Our Case Number: ABP-314724-22

Re: Railway (Metrolink - Estuary to Charlemont via Dublin Airport) Order [2022]
Metrolink. Estuary through Swords, Dublin Airport, Ballymun, Glasnevin and City Centre to
Charlemont, Co. Dublin

Metrolink submission (Railway Order) 2022

This submission focuses solely on traffic, vehicular access & safety concerns I have as a resident, with regard to the proposed Station at Glasnevin.

Narrowest section of towpath (highlighted in red) approx. 50m long

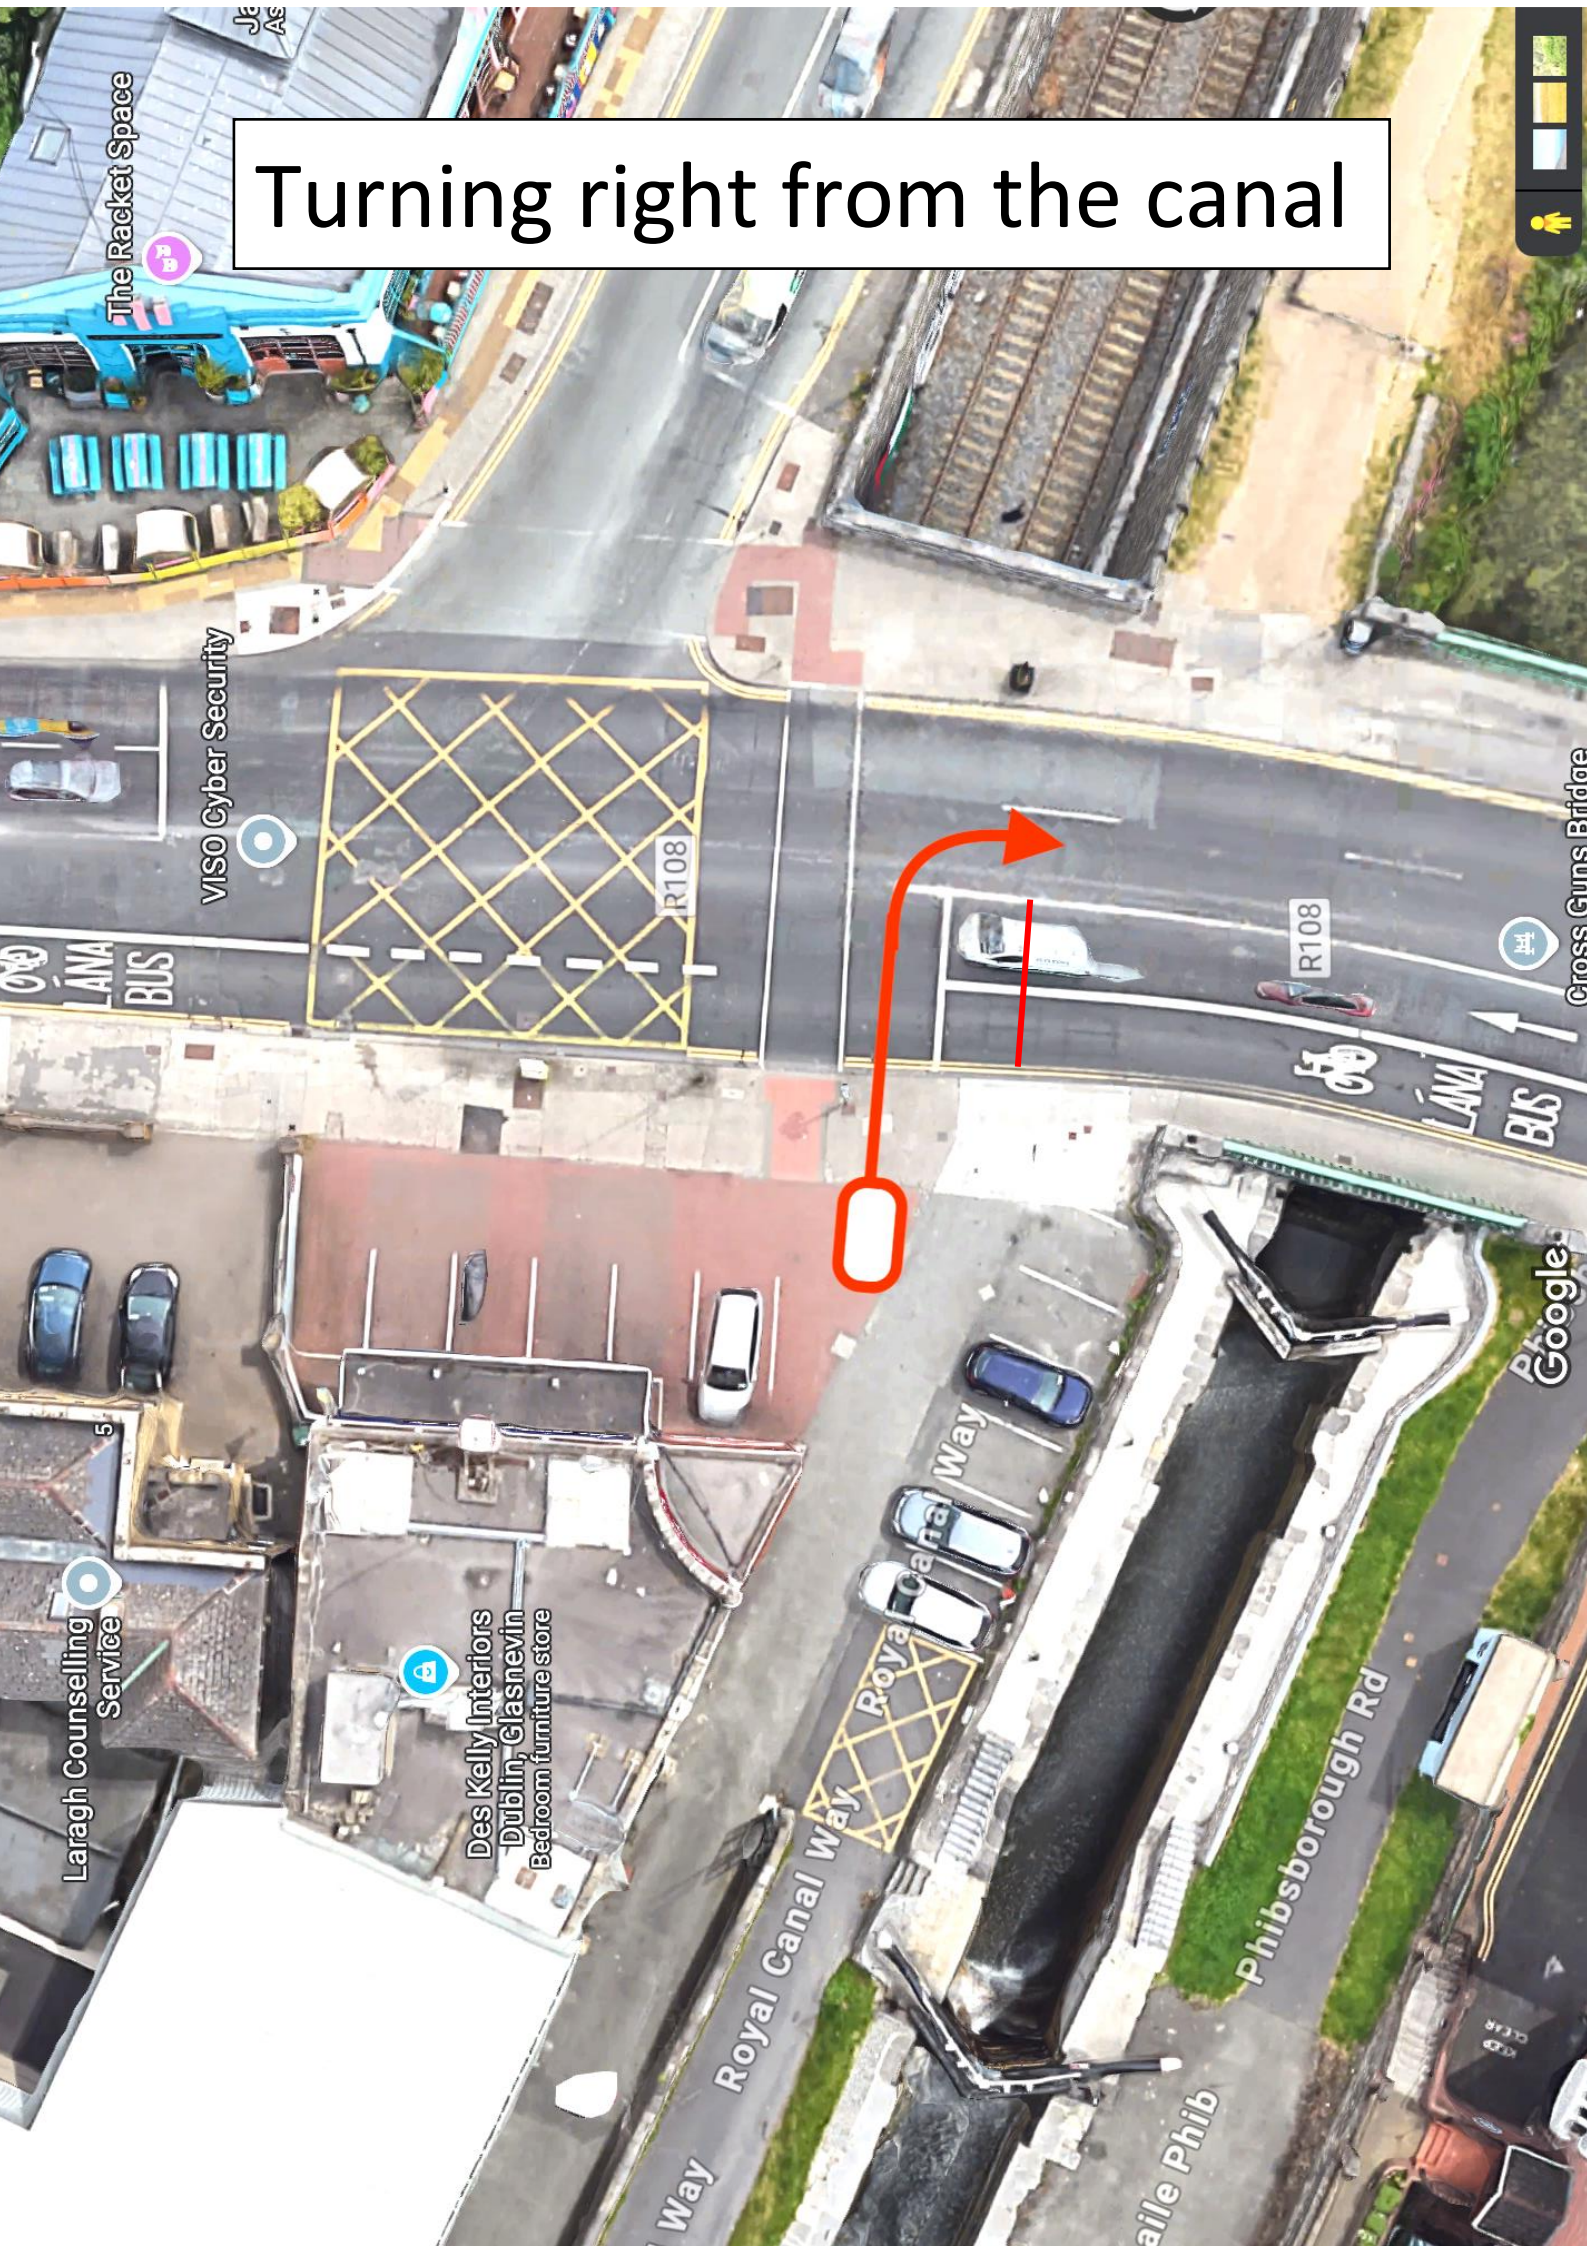
I have very serious concerns regarding vehicular and pedestrian safety along the section of towpath between the station and the canal. See below.

The towpath is only 3.3m wide here and all vehicles must pass this point. It stretches for approx. 50m and is undoubtedly the greatest point of danger along the towpath, as the water is very deep here and there is no riparian verge.

TII's response to previous queries about the final width of the towpath here was that “**the access road will be no narrower than it presently is**”. However, this worries us greatly, as at present it is already highly dangerous and will only get worse when the station is up and running, due to the inevitable increased footfall and frequency of bicycles & scooters.

Surely TII would have to adhere to legal safety standards, before reopening this stretch of road to the public? And 3.3m does not meet those standards.

I believe TII needs to address this issue immediately, as it might require difficult structural changes to the plan at this point.

Enter right coming from the North & left from Phibsboro

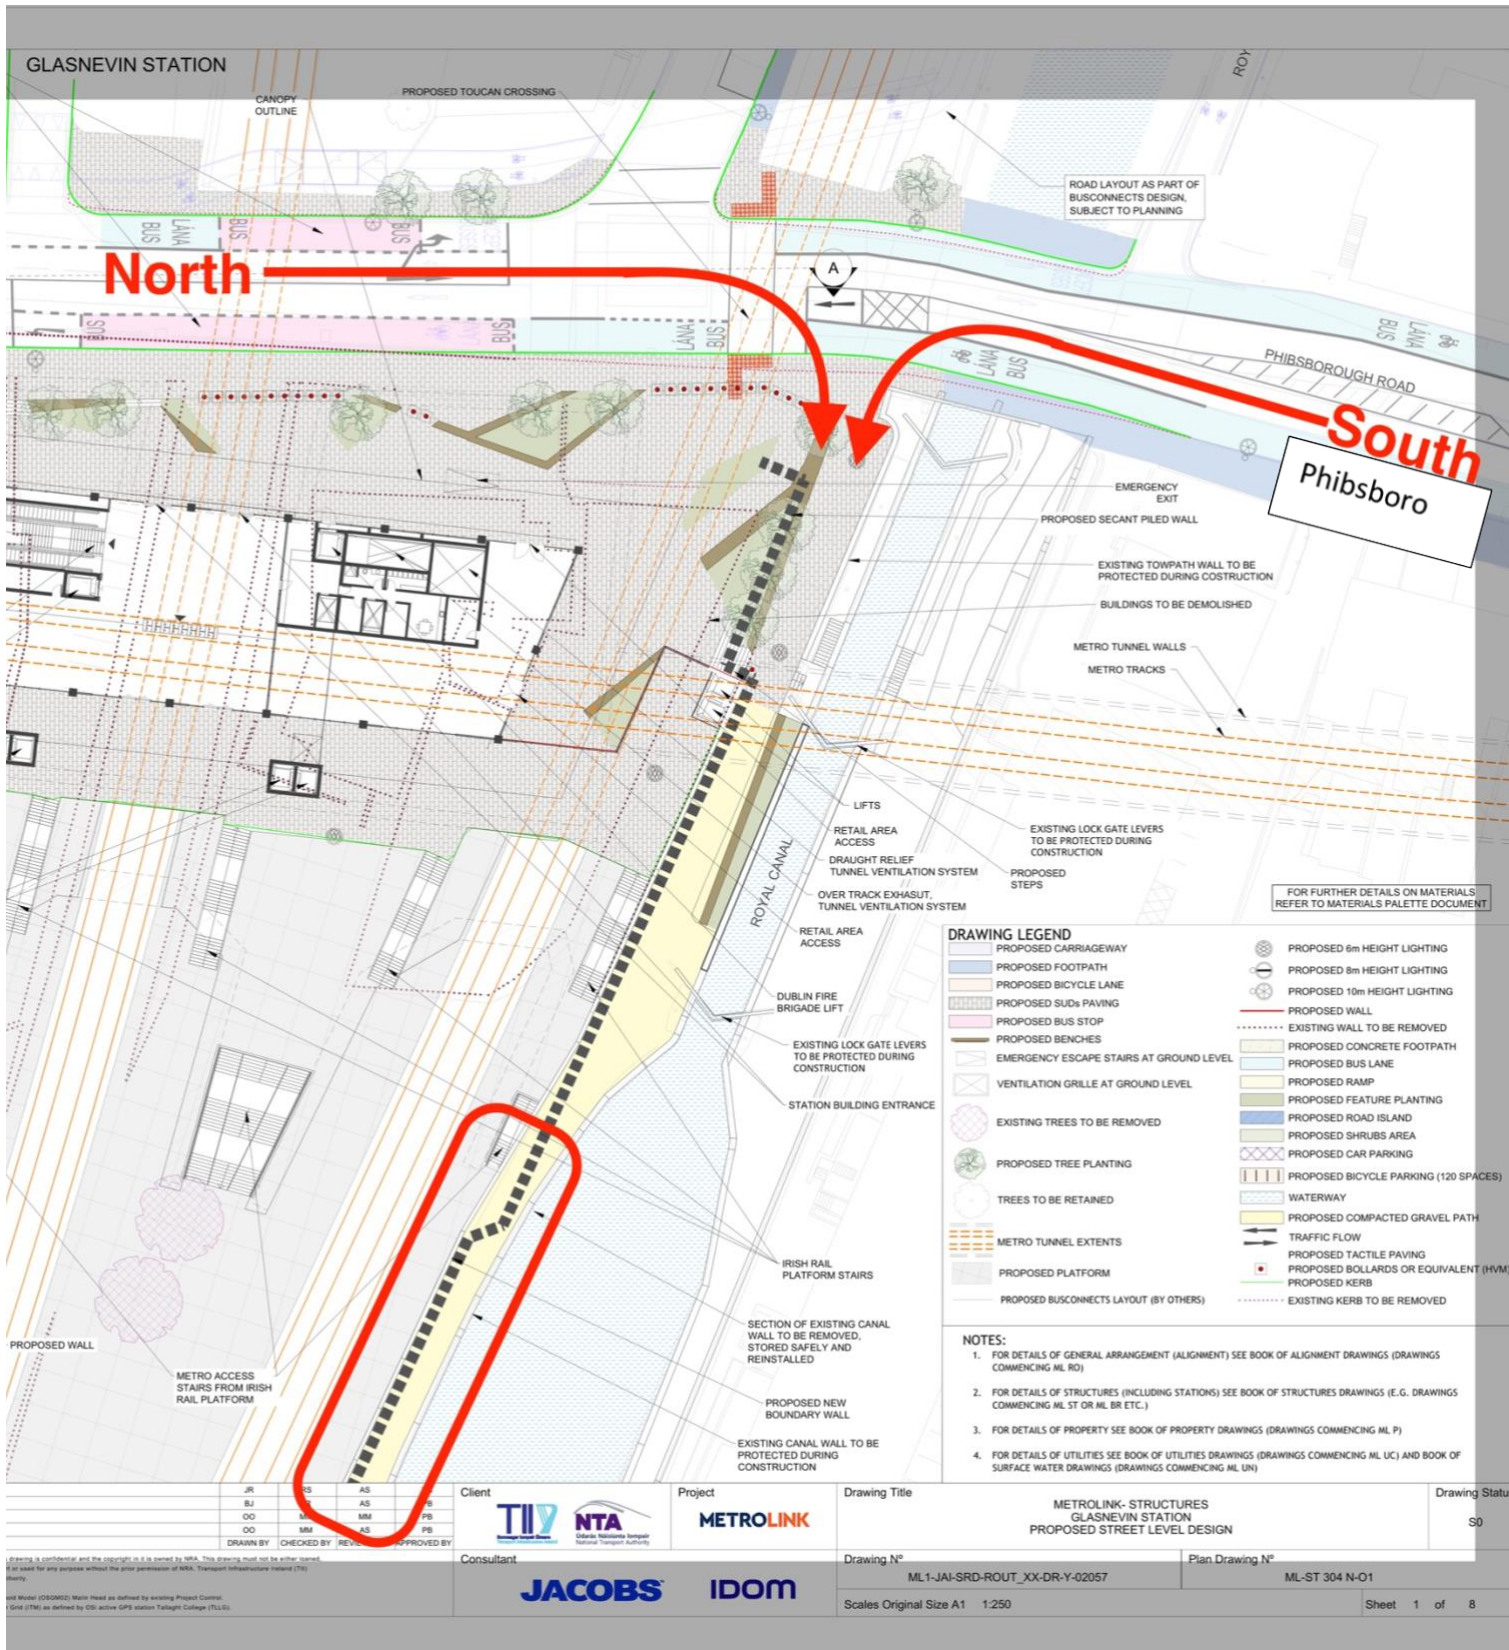
In the image above, where should traffic approaching from the north (red arrow) wait before pulling across? With the absence of a filter light, it would be absolutely essential that there should be no pedestrians blocking vehicles trying to pull across.

How is this to be achieved?

**GLASNEVIN STATION - LONGITUDINAL SECTION**  
1 : 200

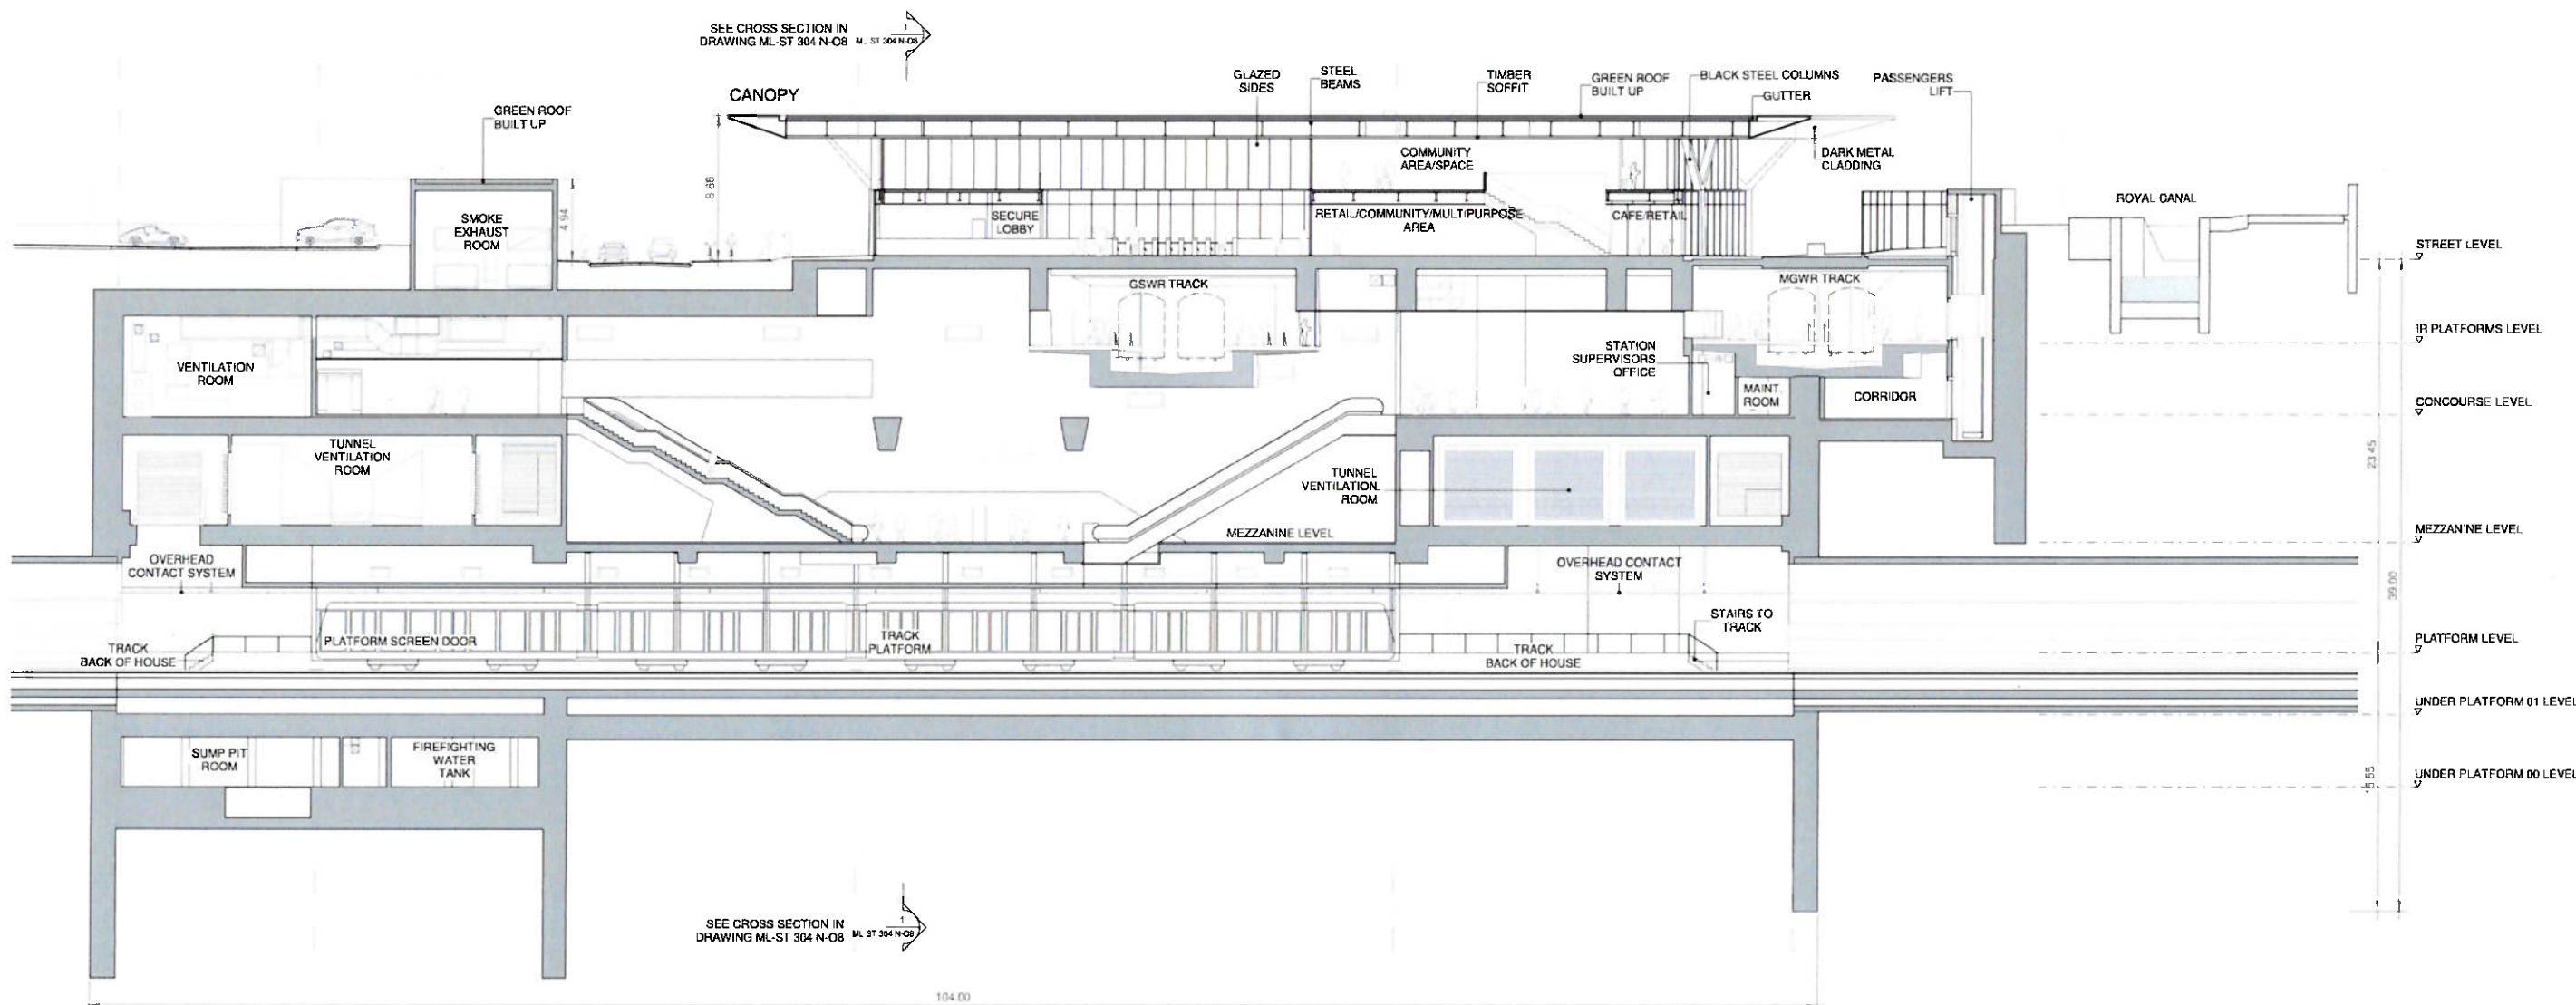
I would like to focus first on vehicles exiting and entering through the concourse at Glasnevin. In my opinion this has not been adequately analysed by Metrolink, especially when one takes into account traffic changes underway at present for the Royal Canal Greenway Phase 3.

I can find very little reference, visual or otherwise, to vehicular access in any of the Metrolink documents and no reference to heavy vehicle access.

I can find no detail in new plaza layout, indicating how traffic should exit and enter. Will there be a filter light for instance? Also I see only one yellow junction box, in the outer lane, where obviously 2 would be needed, to stop vehicles in the bus lane blocking vehicles exiting from the Royal Canal Way
